Appendix C – Response to Submissions Table (SSD-79791208)

Key Issues	Response
Approved Concept Plan	
<p>Consent was granted for a concept proposal on the site on 26 April 2024 (SSD-49808717). The current State significant development (SSD) relies on Section 4.24(4) of the <i>Environmental Planning and Assessment Act 1979</i> (EP&A Act), where a development application (DA) may be inconsistent with a concept consent subject to a condition requiring the modification or surrender of the concept consent. In this instance, the application requests a condition to modify the concept consent under Section 4.17(b) of the EP&A Act.</p> <p>Noting this, provide further detailed assessment of the proposal against the conditions of the concept consent (revising Appendix SS of the EIS), to specifically confirm if the proposal satisfies existing conditions or where the application is seeking to modify a condition under Section 4.17(b) of the EP&A Act. If the latter, please propose recommended amendments to the condition for the Department’s consideration.</p>	<p>The Stage 1 SSDA Development Consent Conditions Response Table provided at Appendix RR submitted with the EIS has been updated to provid

Accessible Hotel Type 03

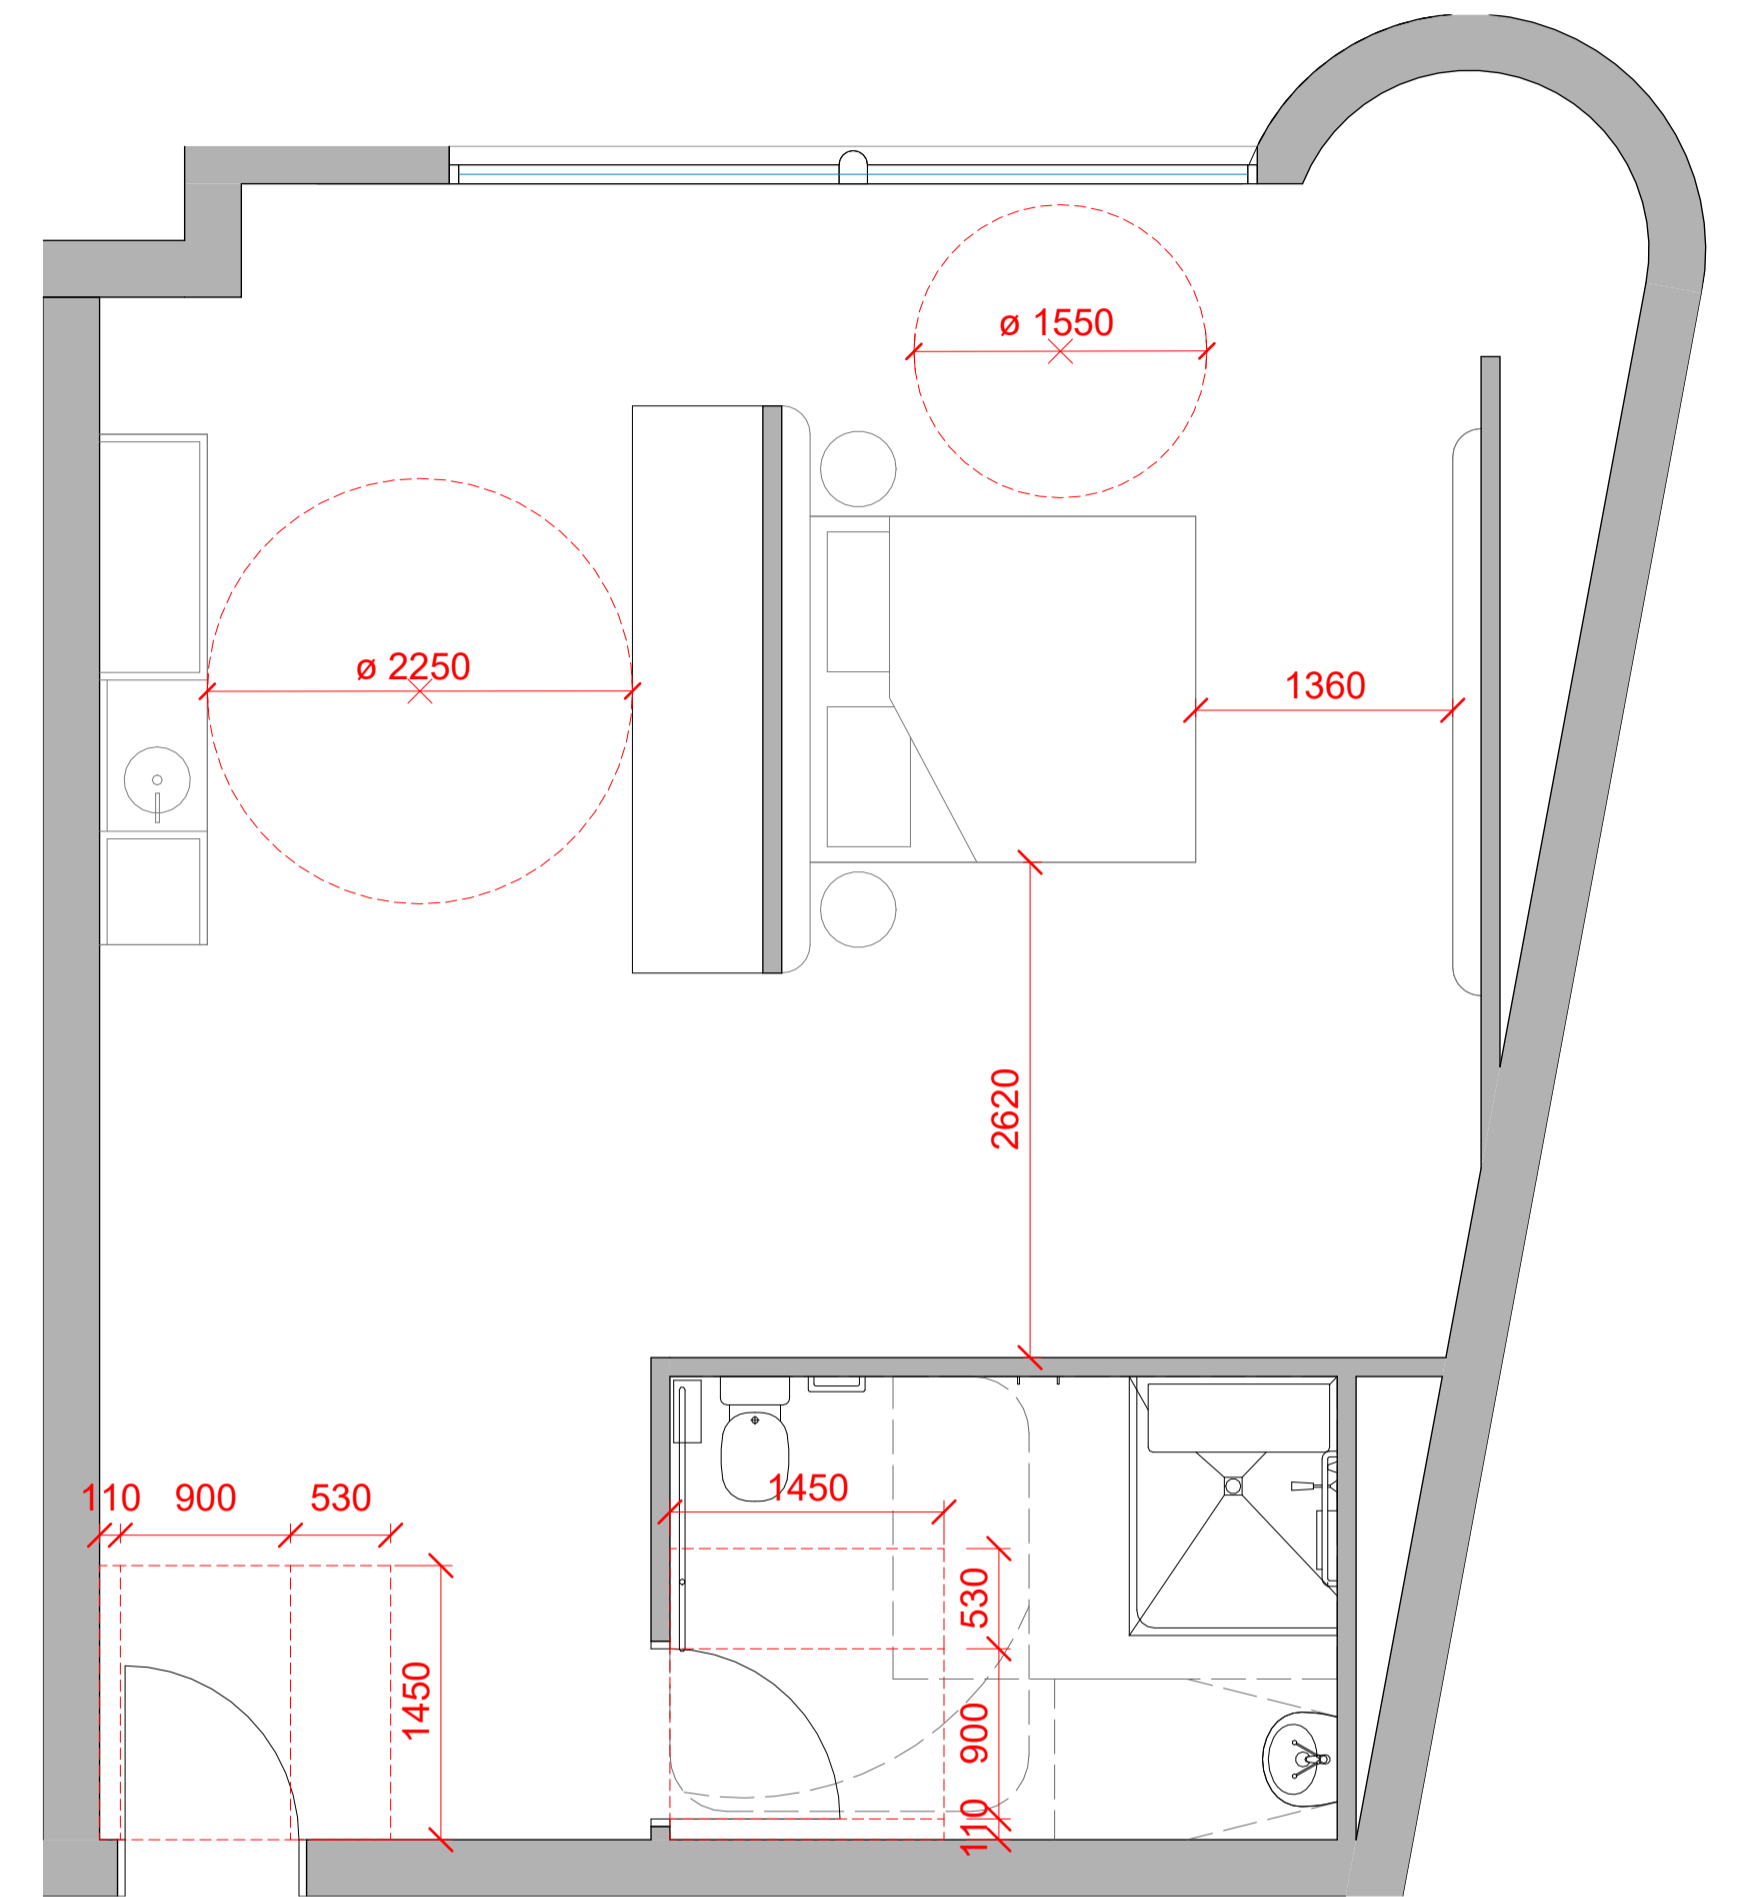
Key Issues	Response
Adaptable, liveable, affordable and NDIS housing	
<p>The location of the NDIS housing (and carer apartments) is not clear. These are proposed as adaptable apartments; however, the proposed number of adaptable apartments differs from the proposed number of NDIS apartments. Clearly identify the number and location of the NDIS housing, carer apartments and adaptable apartments on the proposed plans.</p> <p>The affordable apartments are located on the lower levels, being 7 to 11. Provide further consideration and justification of the proposed location of the affordable apartments, especially in terms of amenity when compared to dwellings at upper levels.</p> <p>Alongside the proposed provision of 61 adaptable apartments, 18 accessible parking spaces are proposed. Clarify the adequacy, management and allocation of accessible parking.</p> <p>Given the total number of adaptable apartments to be delivered from the outset for general BTR residents is likely to be allocated to NDIS and carer residents, the Department requests further consideration given to the total number of adaptable apartments provided from the outset. In addition, the Department requests further clarification from the operator with respect to how and when any adaptable apartments not allocated (and adapted) prior to construction will be adapted in response to any potential tenant request.</p> <p>Provide further justification to support the proposed number of liveable apartments (61), which is considerably less than 20% recommended by the ADG (141 apartments).</p>	<p>A detailed response to the Department’s comments regarding adaptable, liveable, affordable and NDIS housing is provided within Section 4.8 of the Submissions and Amendments Report. In summary, the following responses are provided:</p> <ul style="list-style-type: none"> • The proposal comprises a total of 61 adaptable apartments, which are located within the western tower. Of the total amount, 50 (including 5 carer apartments) are proposed as Special Disability Accommodation (SDA) to be operated under the NDIS. SJB have provided additional architectural drawings to illustrate the pre- and post-adaptable layouts of the relevant apartments, which is provided within the Addendum Architectural Design Report at Appendix F. • 50 affordable apartments are proposed to be located between Levels 6 and 11 of the eastern tower. Despite their location within the lower levels of the tower, it is emphasised the apartments receive a high level of residential amenity, particularly as 60% of the affordable apartments will be naturally ventilated and 70% of the apartments will receive solar access for 2 hours. • The proposed development comprises 21 accessible parking spaces, which does not provide an accessible space for every adaptable unit. However, as confirmed by MyLife (refer to Appendix U), the provision of 18 accessible spaces, 32 standard spaces and 1 additional space for carer apartments is sufficient to meet their operation requirements. • Whilst the proposed development does not incorporate the recommended 20% of liveable apartments, the design and operational approach of the adaptable apartments exceed the minimum requirements of the ADG. Rather than solely incorporating LHG silver level features, the proposal integrates NDIS SDA design standards to accommodate occupants with higher care needs, representing a more substantial commitment to equitable and universal access, therefore directly achieving Objective 4Q-1 of the ADG. <p>Refer to Section 4.0 of the Submissions and Amendments Report for a more detailed assessment of the relevant matters.</p>

<p>Universal Access</p> <ul style="list-style-type: none"> - Council recommends that the accessible pathways and adaptable units should be addressed in a revised application. - Council recommends that an additional 45 adaptable units be provided to ensure compliance with Part 4Q of the Apartment Design Guide. - Council encourages the additional provision of accessible rooms within the hotel, in accordance with the requirements of Part D4 of the National Construction Code. 	<p>The proposal provides a total of 61 adaptable apartments, which exceed the standard liveable housing guidelines by adopting the SDA NDIS standards. While this falls short of the recommended amount under the ADG and the DCP, it is considered that for the large scale of the development and its use as BtR, the provision of 61 adaptable apartments is more than suitable. Further justification on the quantum of adaptable apartments is provided within Section 4.8 of the Submissions and Amendment Report.</p> <p>In relation to accessible rooms within the hotel, accessibility measures will be incorporated into the design of the hotel rooms at the detailed design stage of the development.</p>
